From: Martyn White
Sent: 09 August 2019 15:19
To: Planning.Responses <Planning.Responses@arun.gov.uk>
Subject: R/170/19/DOC

R/170/19/DOC

SLIMLITE
DOUBLE
GLAZING
SCALE 1:1

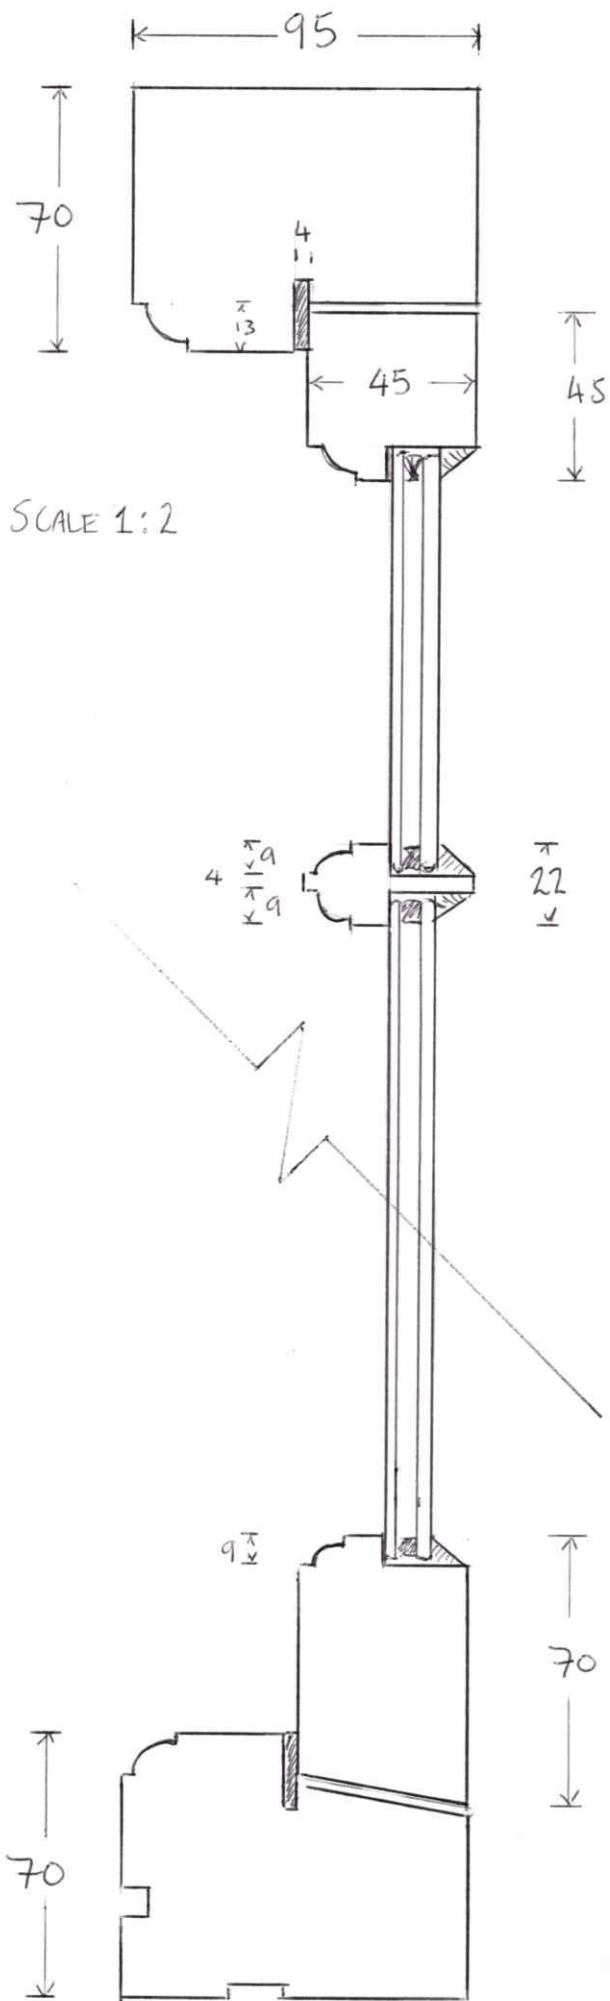
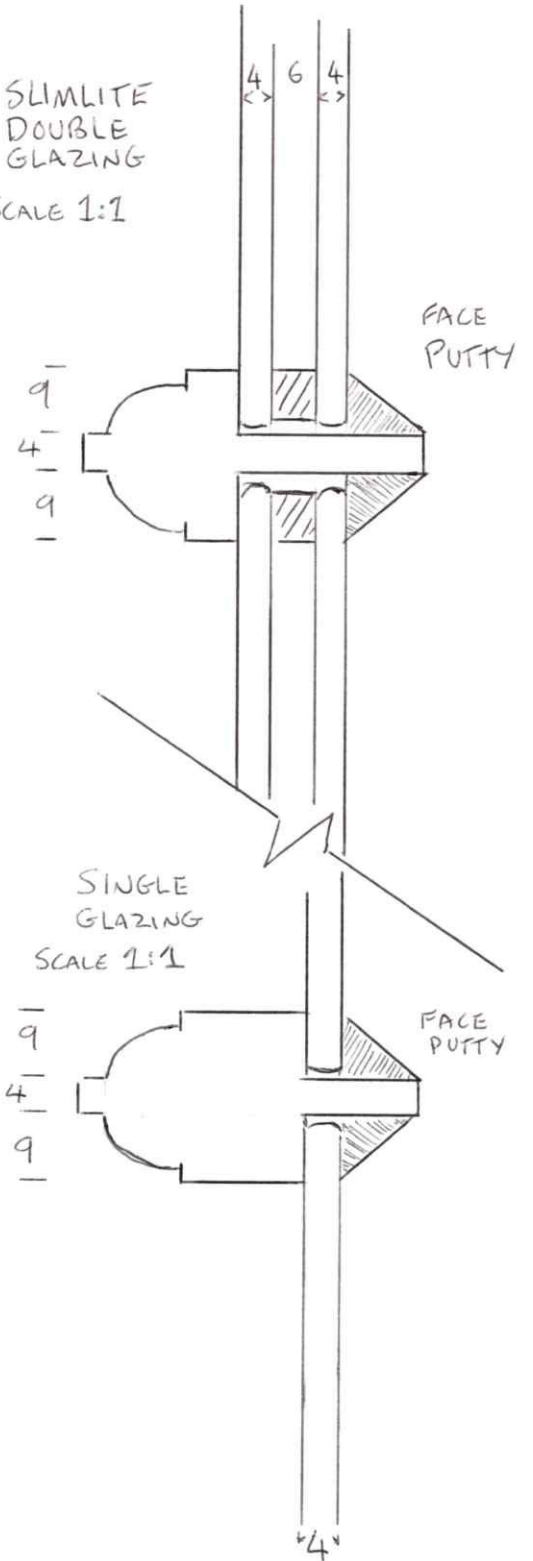
I have reviewed the details of the replacement windows and consider that they are acceptable.

CASEMENT WINDOWS  
REF: PALM COTTAGE

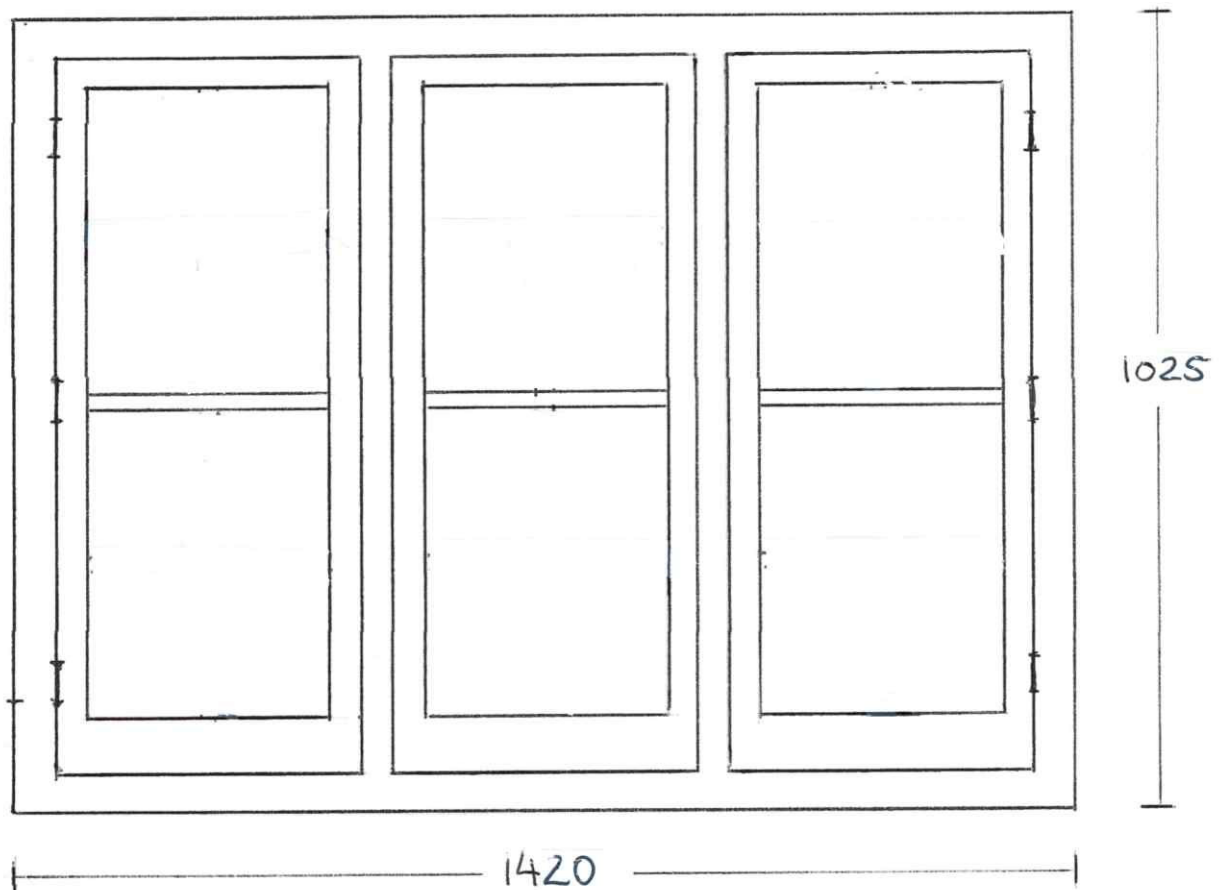
I note that reference is made within the condition regarding the finish of the windows. Is the applicant able to provide details of this, including the proposed colour if it is to change?
